8 OAKLEY GARDENS
EAST PRESTON
BN16 1LR

Re: EP/2/21 HH registered 28/1/2021
27a Sea Lane, East Preston

Elevations (1:100)

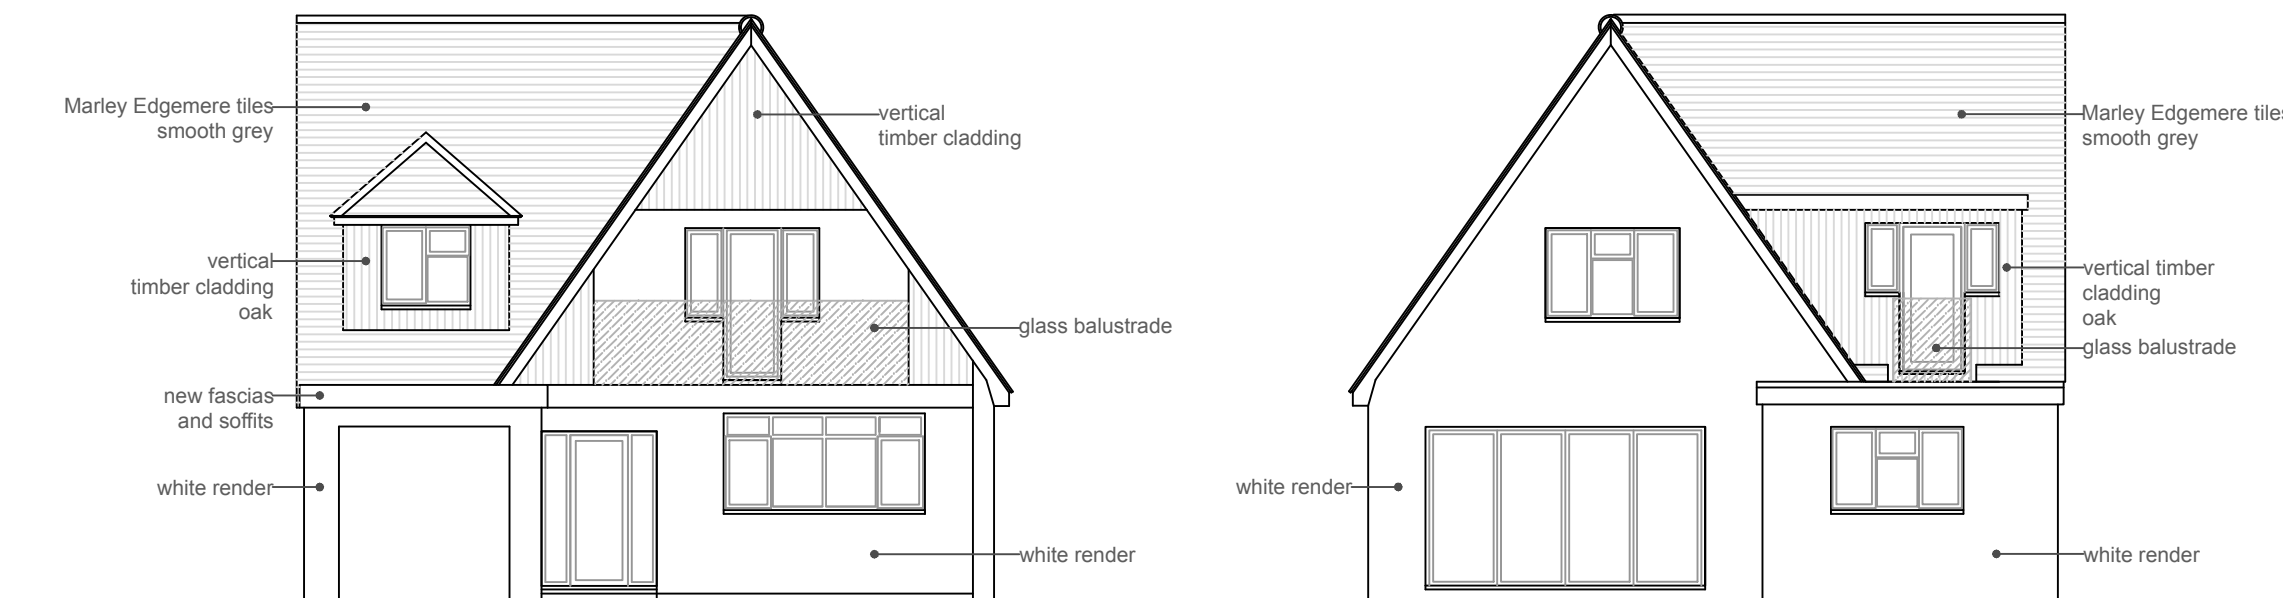
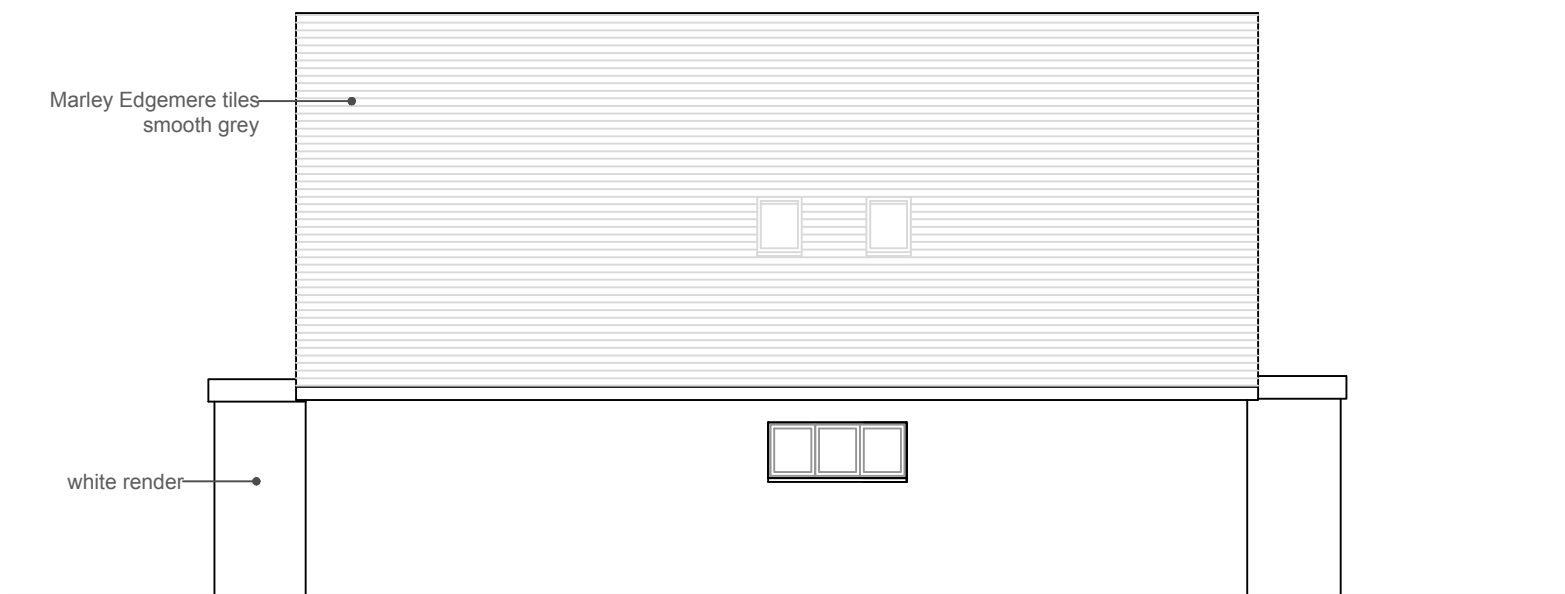
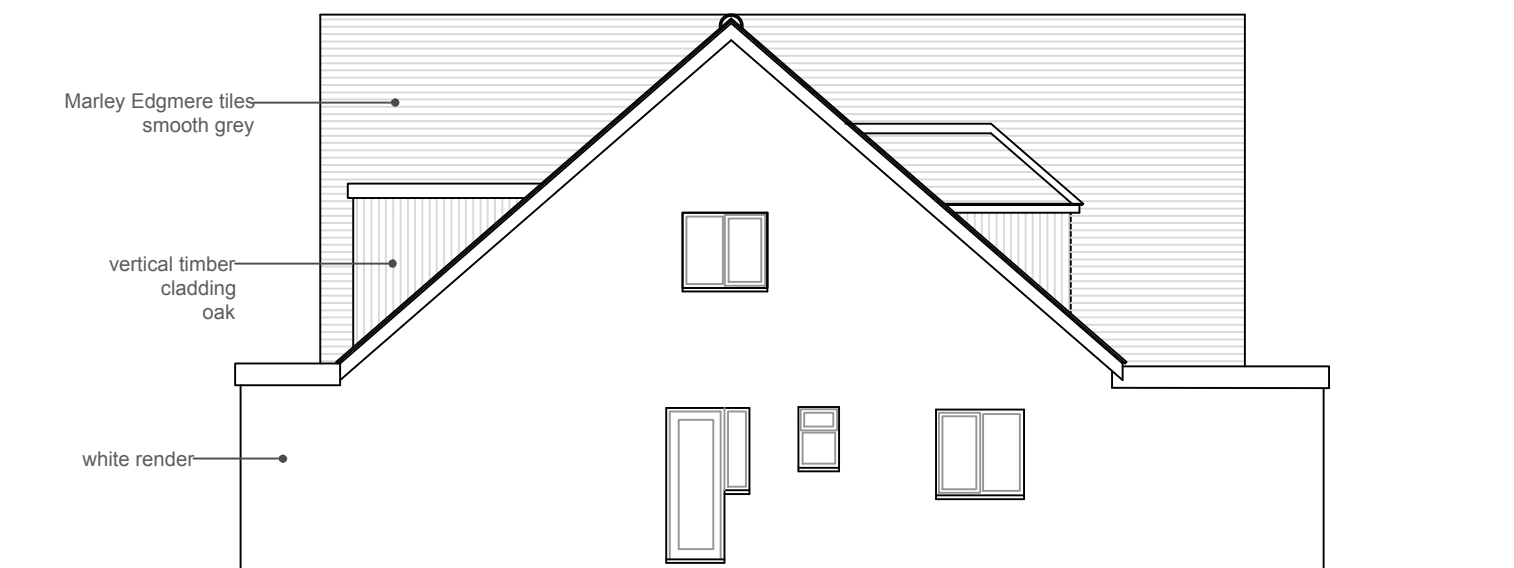
We wish to register our objection
and disgust against the proposed
balcony to the rear of the
property at 27a Sea Lane, as we
will be overlooked a lot more.

We cannot understand the reason
for a balcony at the rear
which will overlook all the
neighbouring gardens. The only
reason will be to nose at
us.

We think it is appalling to
consider putting a balcony at
the rear to look over at
neighbours.
